BUILDING CODE OF AUSTRALIA CAPABILITY STATEMENT - Rev A

Property: Sydney Opera House – DA2 Submission

- **Joan Sutherland Theatre Accessibility**
- **Joan Sutherland Theatre Follow Spot Room**
- **Eastern Accommodation**

BCA Assessment (Joan Sutherland Theatre Follow Spot Room Project ONLY)

3 SECTION - EXISTING FOLLOW SPOT ROOM 02 - DEMOLITION - DA
1 : 50

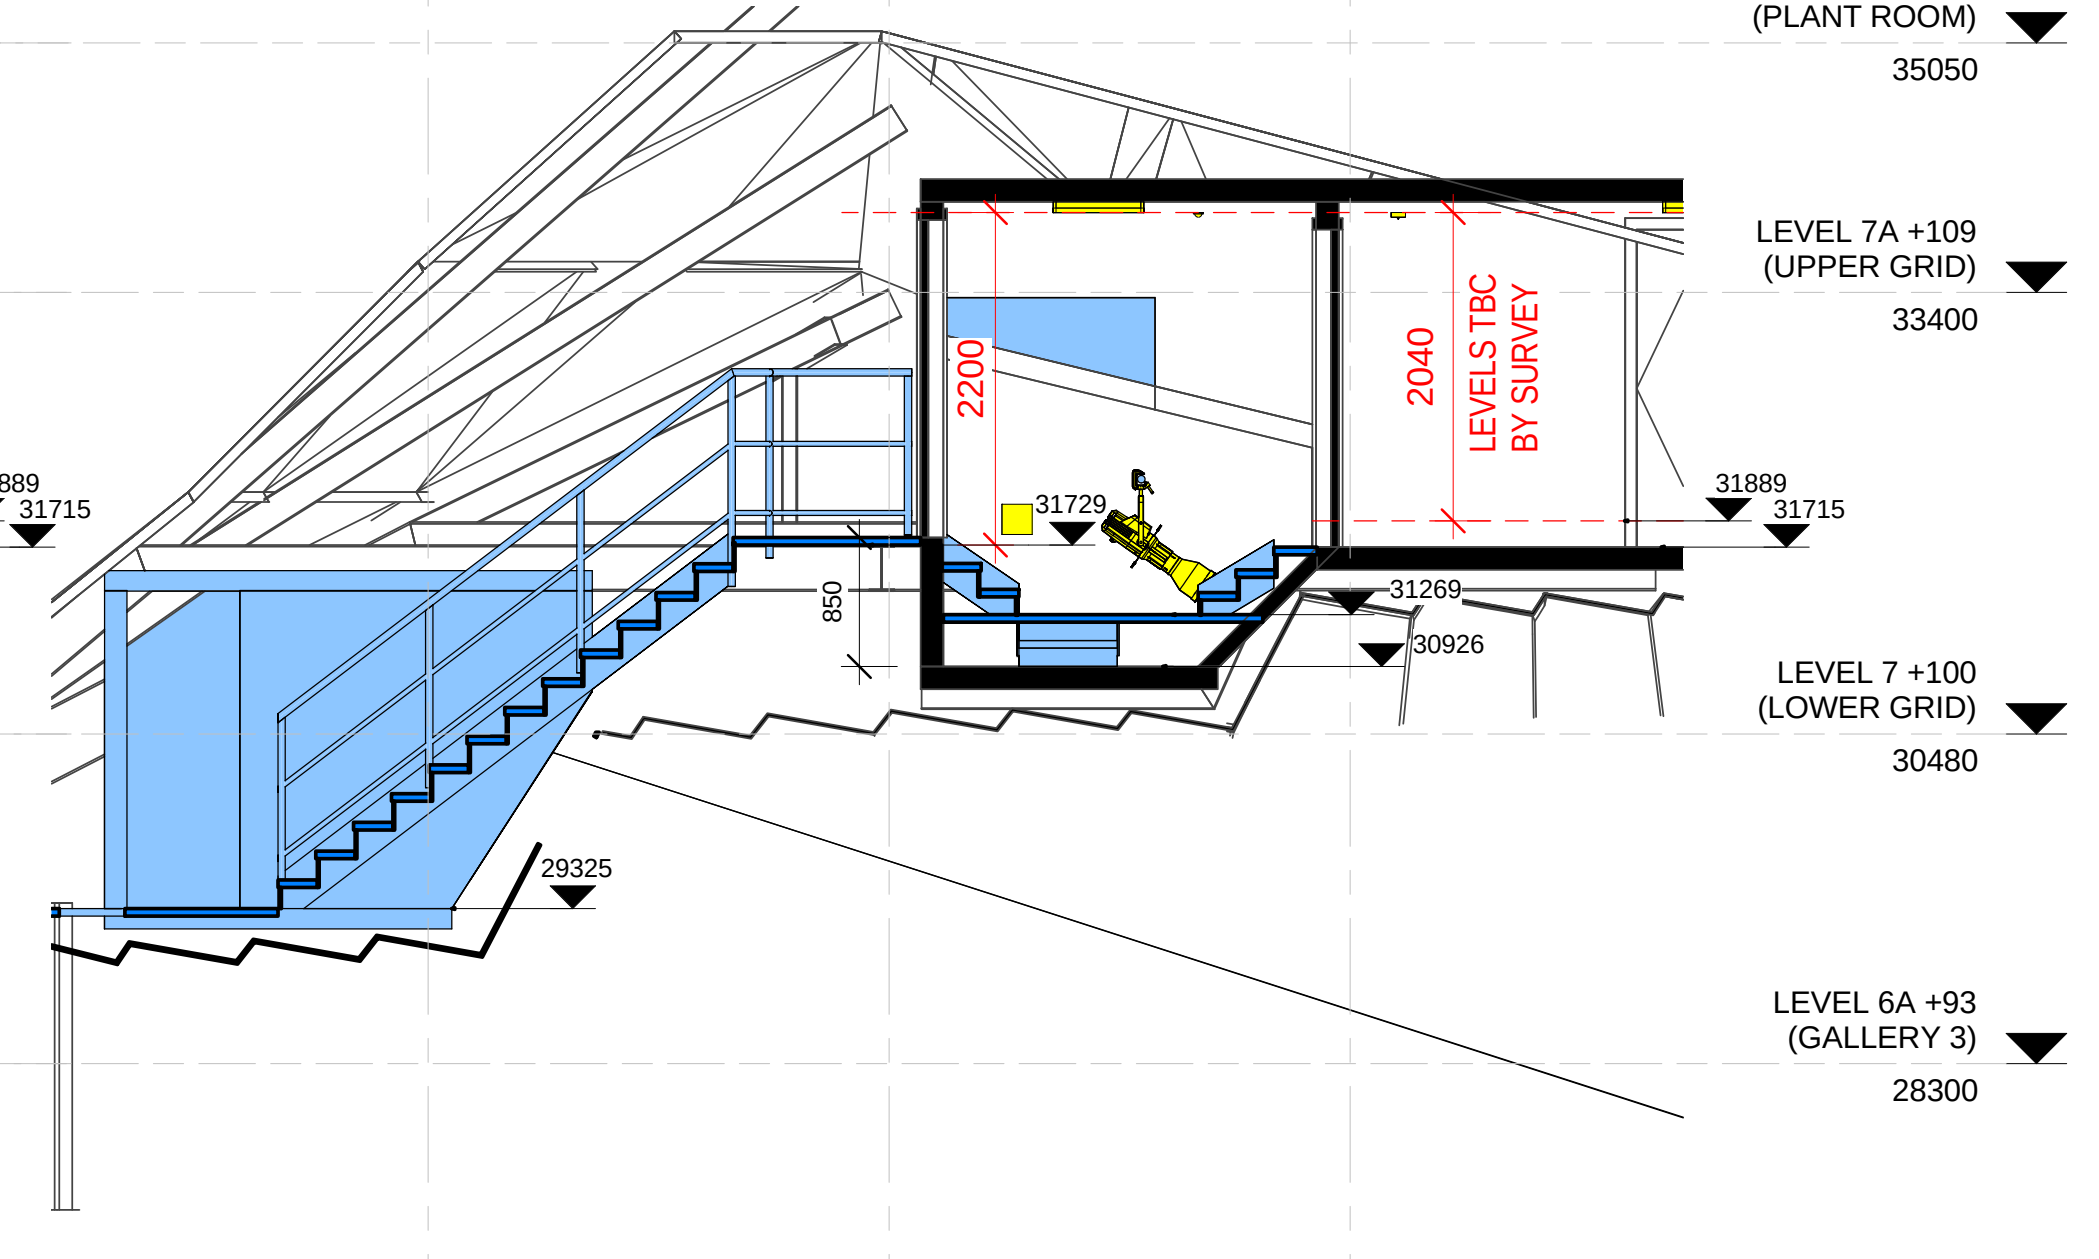
Only one exit from the existing and proposed Follow Spot Rooms is proposed where no less than two are required. The Fire Safety Engineer will need to consider the feasibility of a Performance Solution. It is understood that the area in question will have low number of trained staff present at various times.

Plans illustrating the existing exits are required to be developed for further assessment of the altered travel distances due to the new wall layouts. The BCA deemed-to-satisfy travel distance limitations are 20 m to an exit, or to a point of choice of travel to two different exits, with an overall distance of 40 m to the nearest of these two exits. And 60 m between alternate exits when measured back through the point of choice. The investigation will consider these parameters but only to the extent where an existing situation has been made worst by the proposed design. Any deficiencies can be considered by the Fire Safety Engineer

1 PLAN - FOLLOW SPOT ROOM - DA
1 : 50

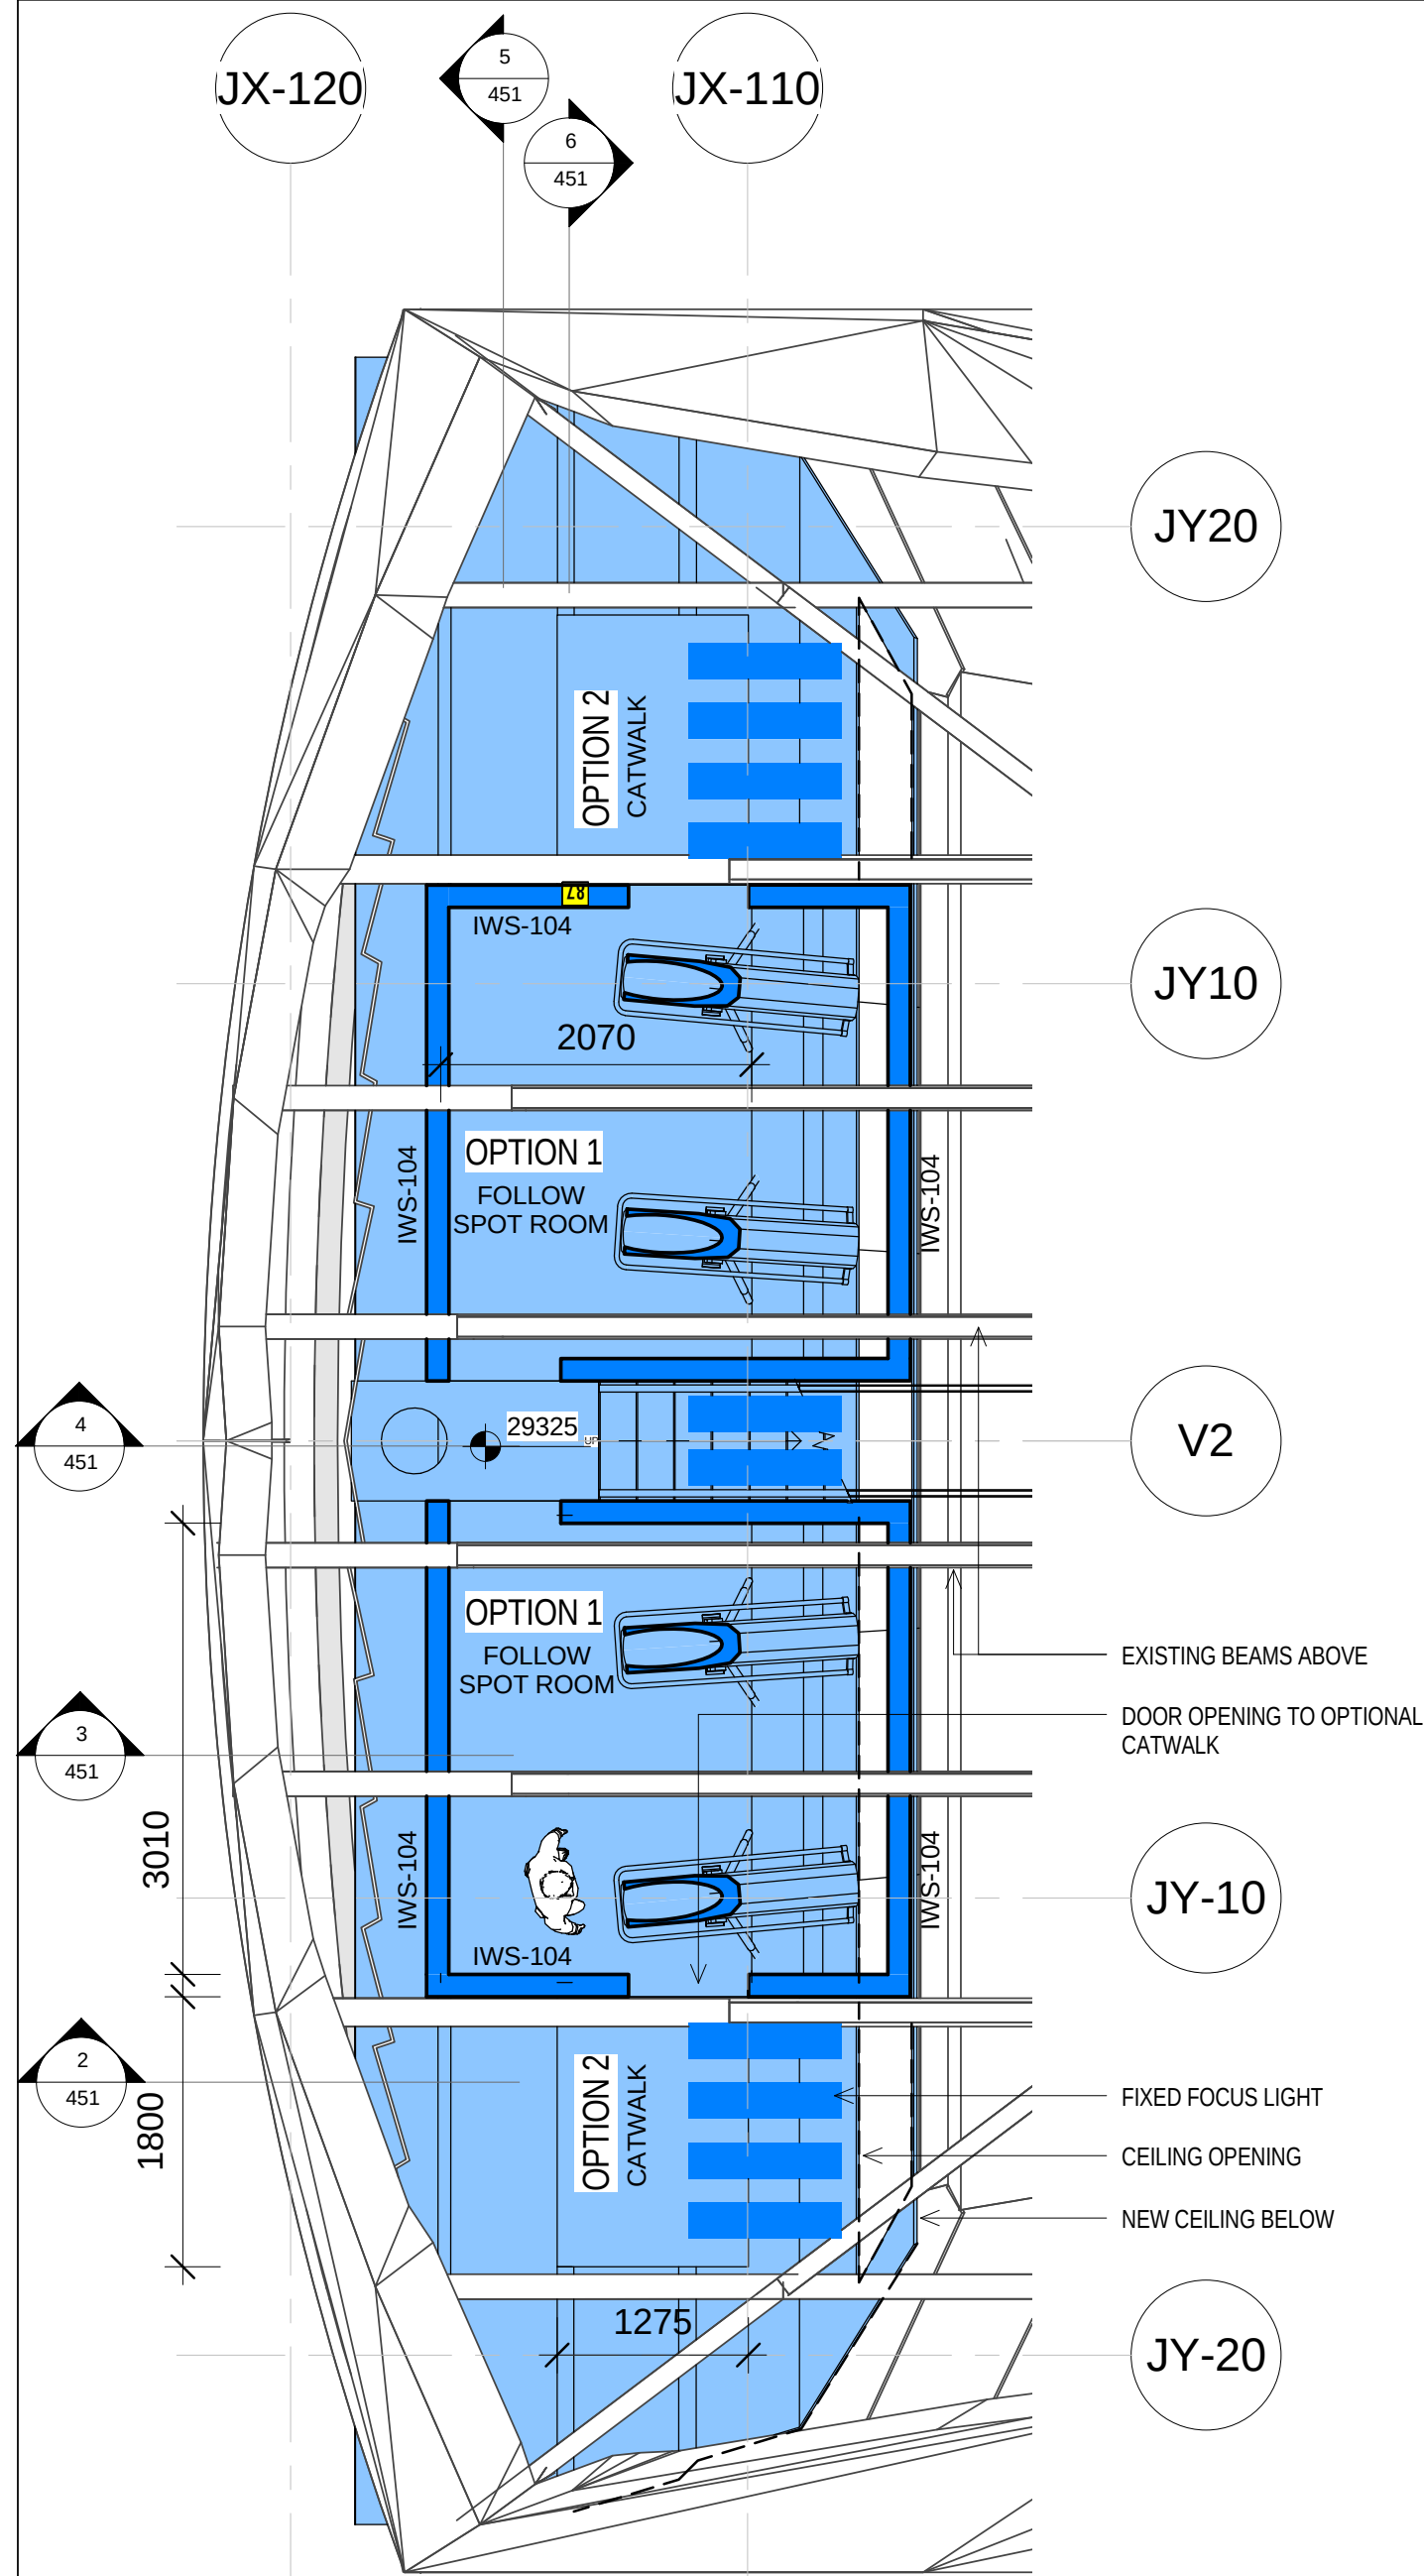
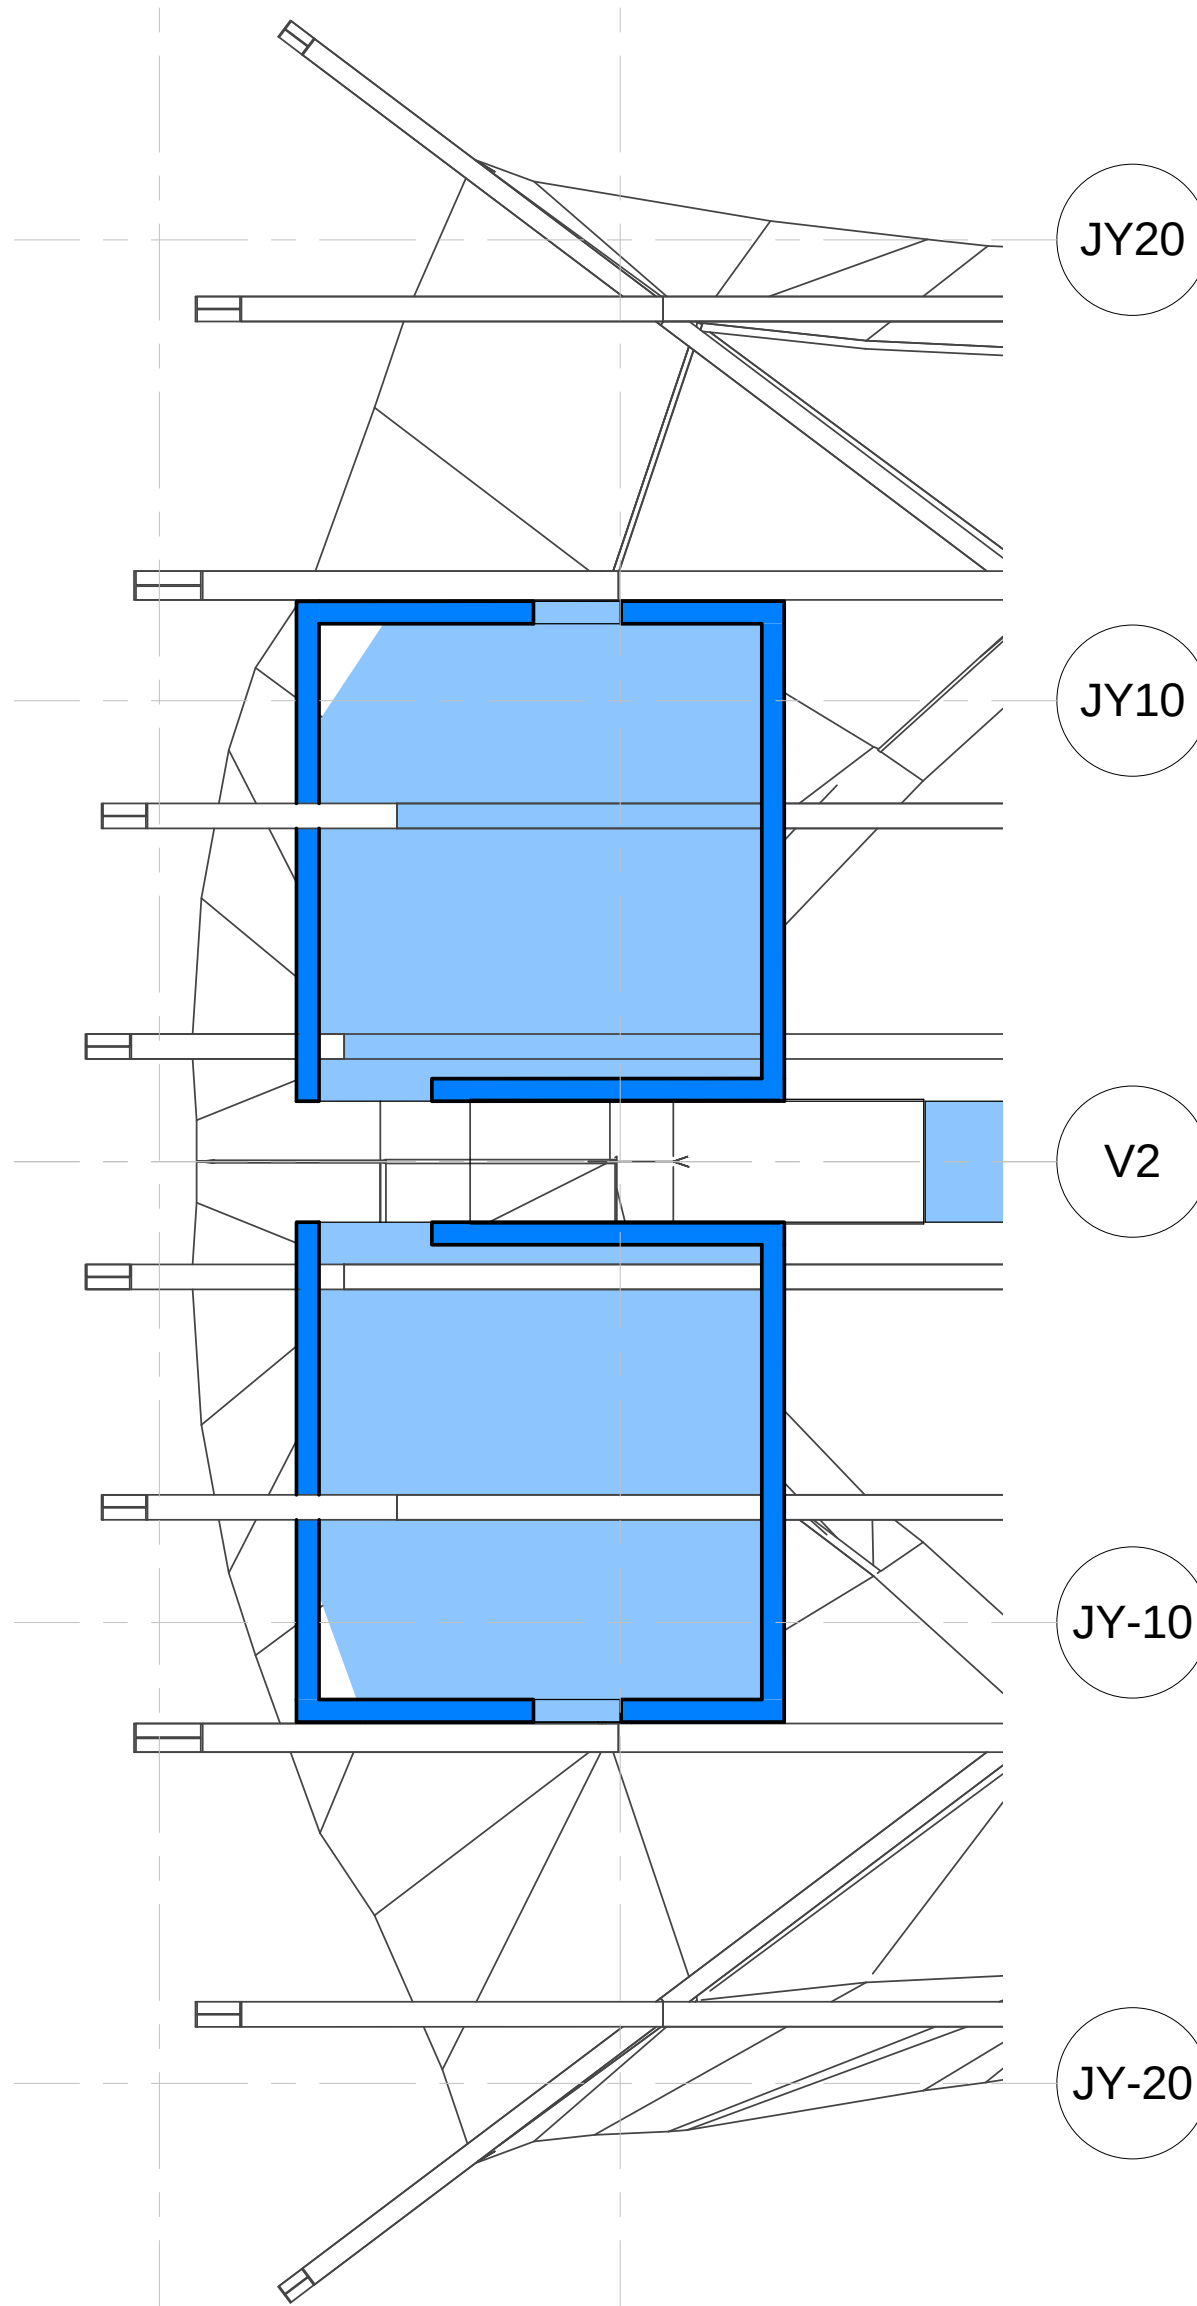
The new floor to the Follow Spot Room is required to be constructed from non-combustible materials and contain an FRL of 120/120/120, or a Performance Solution from the Fire Safety Engineer will need to be considered. The plans illustrate a fire rated plasterboard arrangement consisting of 2 layers of 16 mm Firecheck, the manufacturer and the systems number is required to be nominated for further assessment, i.e. CSR Red Book Version 2 system Number SYS106.

The new steps, balustrade and Portal Openings are required to comply with AS 1657-2013.
